WEST SUSSEX COUNTY COUNCIL CONSULTATION

TO:	Arun District Council FAO:Ms M Tomalova
FROM:	WSCC - Highways Authority
DATE:	21 October 2019
LOCATION:	Former Eastergate Fruit Farm Land at former Eastergate Fruit Farm Eastergate PO20 3RP
SUBJECT:	BN/64/19/DOC Approval of details reserved by condition imposed under ref EG/71/14/OUT relating to Condition Nos 6 - protection of retained trees, 9 - car parking spaces, 10 - road(s), footways & casual parking areas, 11 - construction management plan, 16 - archaeological investigation, 17 - broadband provision and 22 - refuse & recycling bins.
DATE OF SITE VISIT:	n/a
RECOMMENDATION:	Advice
S106 CONTRIBUTION TOTAL:	n/a

17-1103-006-C

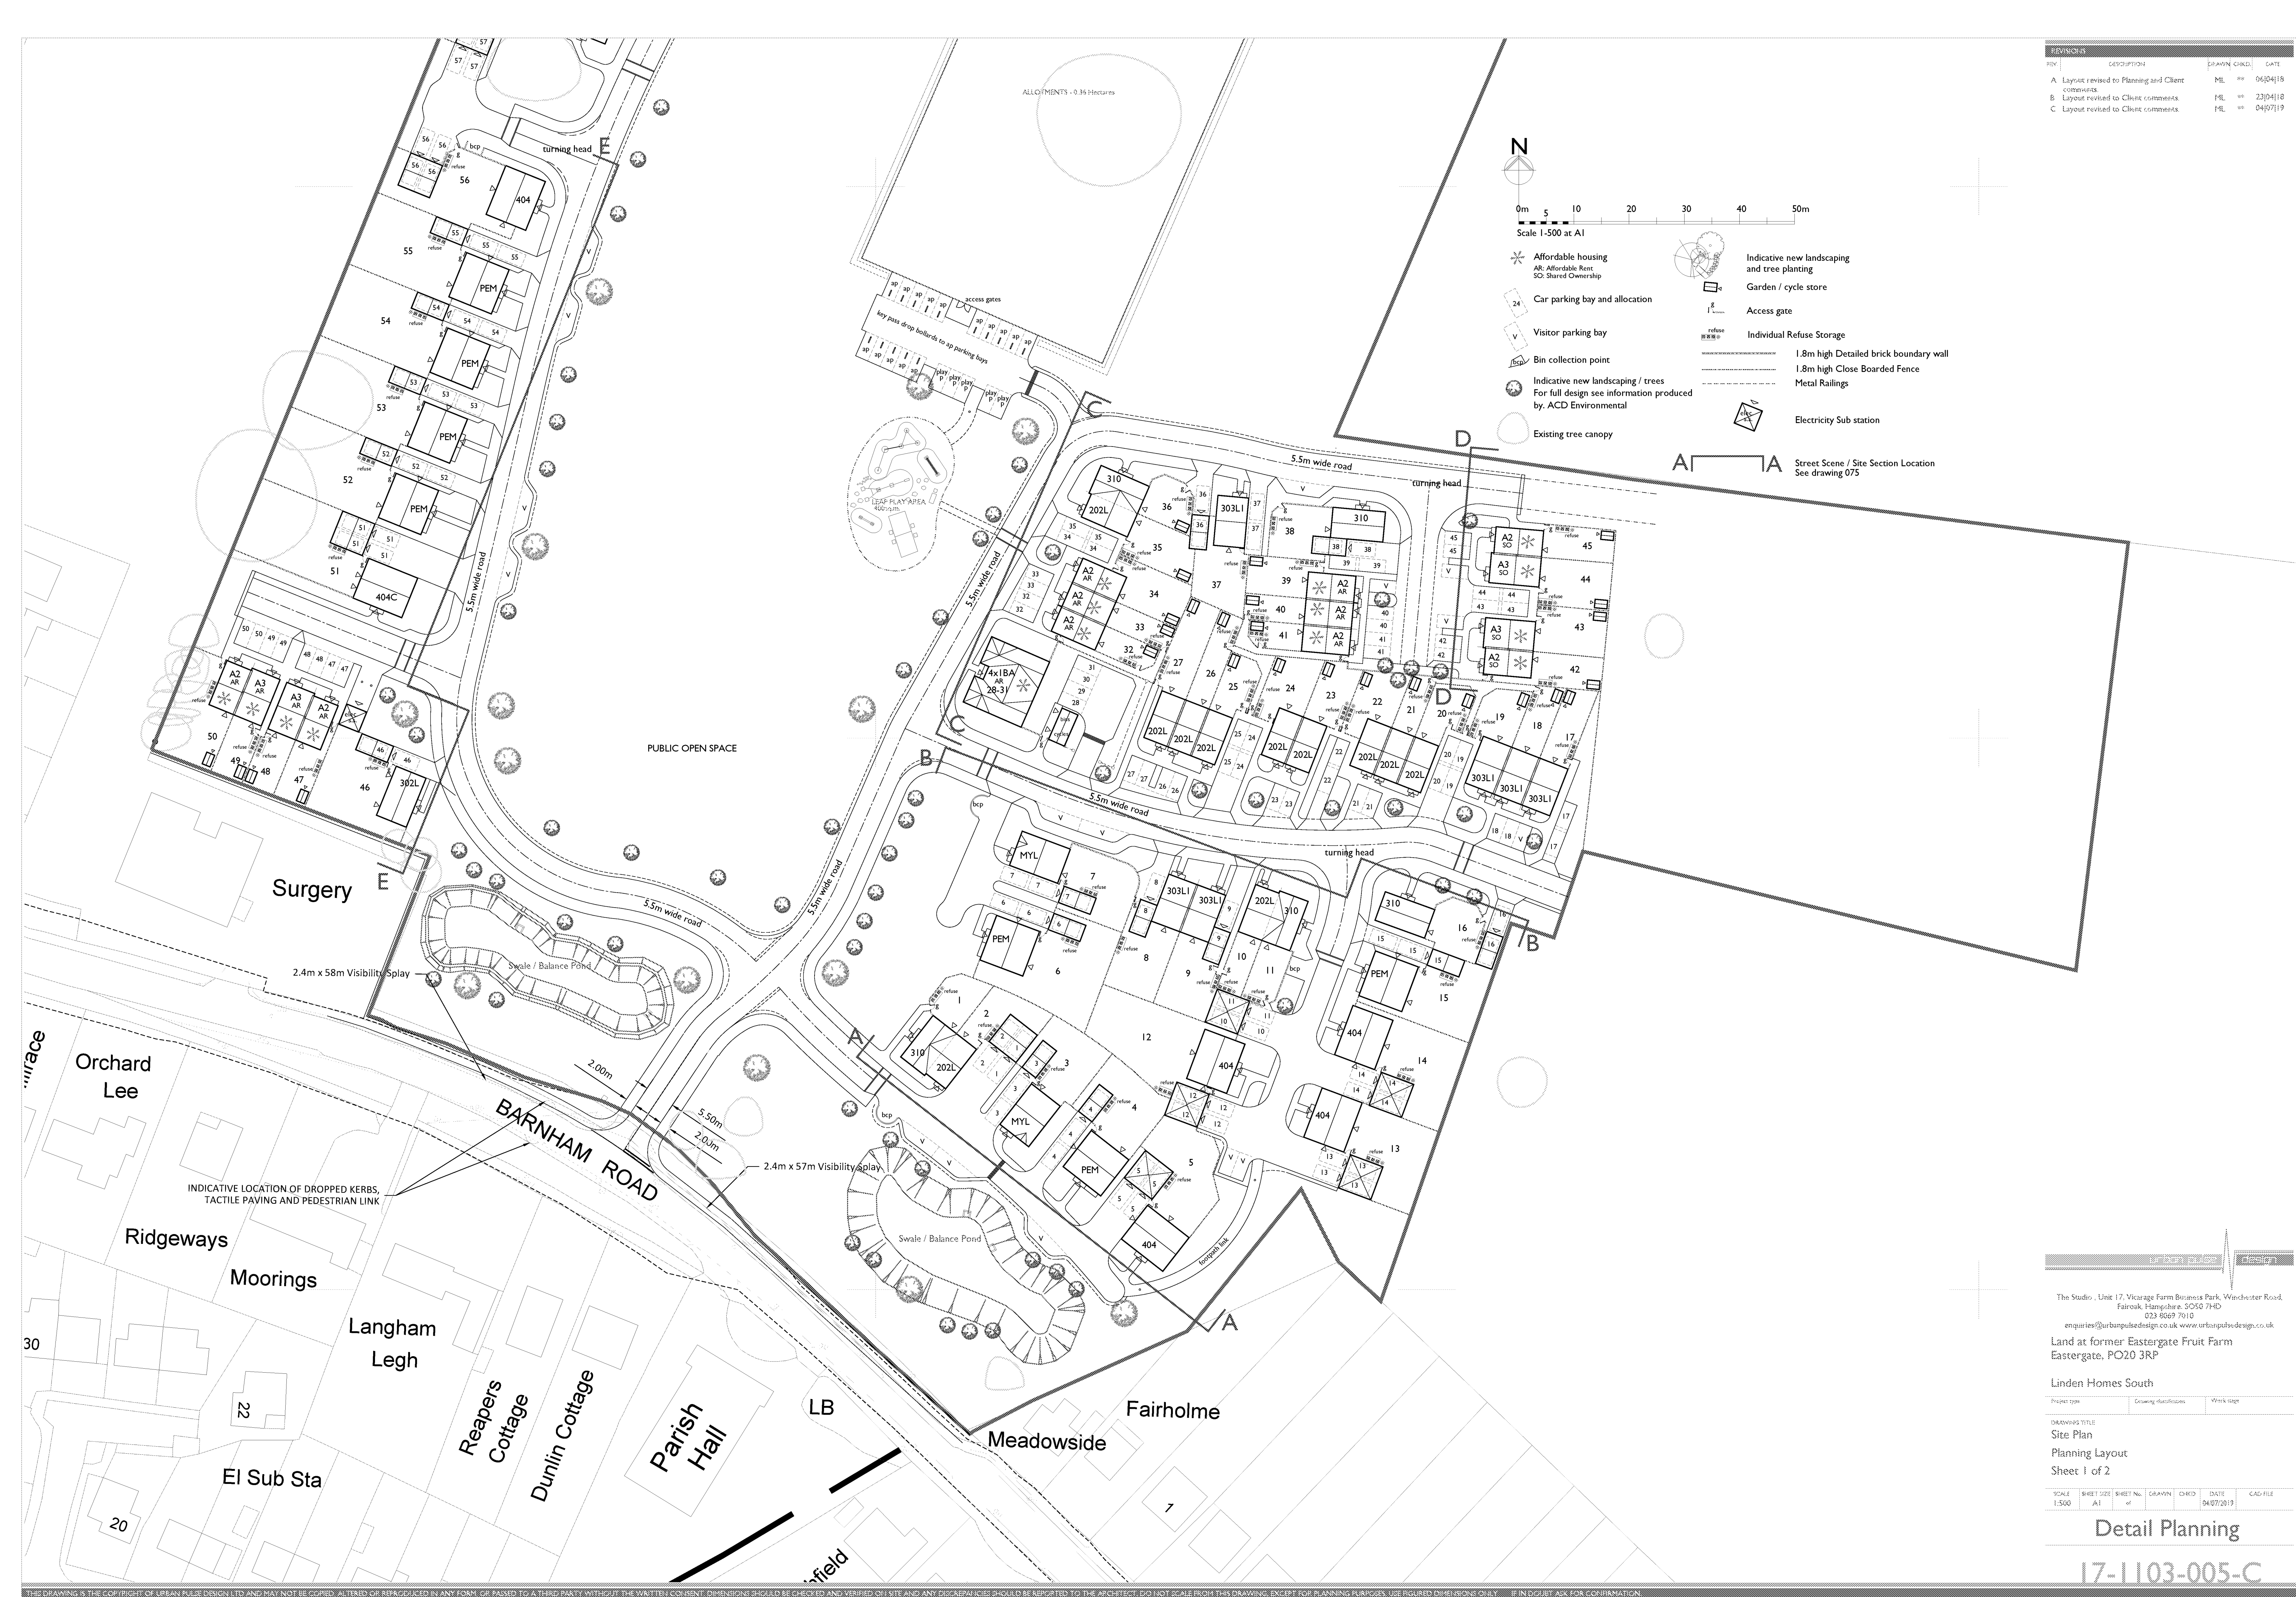
Condition 10 - The submitted plans imply that some of the carriageways, footways, and casual parking areas are to be offered for adoption as public highway. For the purposes of this response, comments are made in terms of the planning acceptability of the highway works as opposed to the acceptability for adoption as public highway. The suitability for adoption would be covered by separate legislative processes with there being the potential for changes to materials as part of the adoption process.

With respects to the details shown, there are numerous locations where what are presumed as over-run areas are included around junctions. The inclusion of such areas is not considered good practice within residential areas given the infrequency of large vehicles that may use these. The swept path of such vehicles in any case are expected to be accommodated within the extent of the highway with no over-running of kerbs. The use of such areas also has the inevitable impact of pushing pedestrian crossing points away from natural desire-lines. In some instances, the crossing points are consequently located in such a way that visibility for those crossing is restricted and as a result introduces safety concerns. It is recommended that all the over-run areas should be removed and the location of all pedestrian crossing points revisited. This should be resolved prior to this condition being discharged.
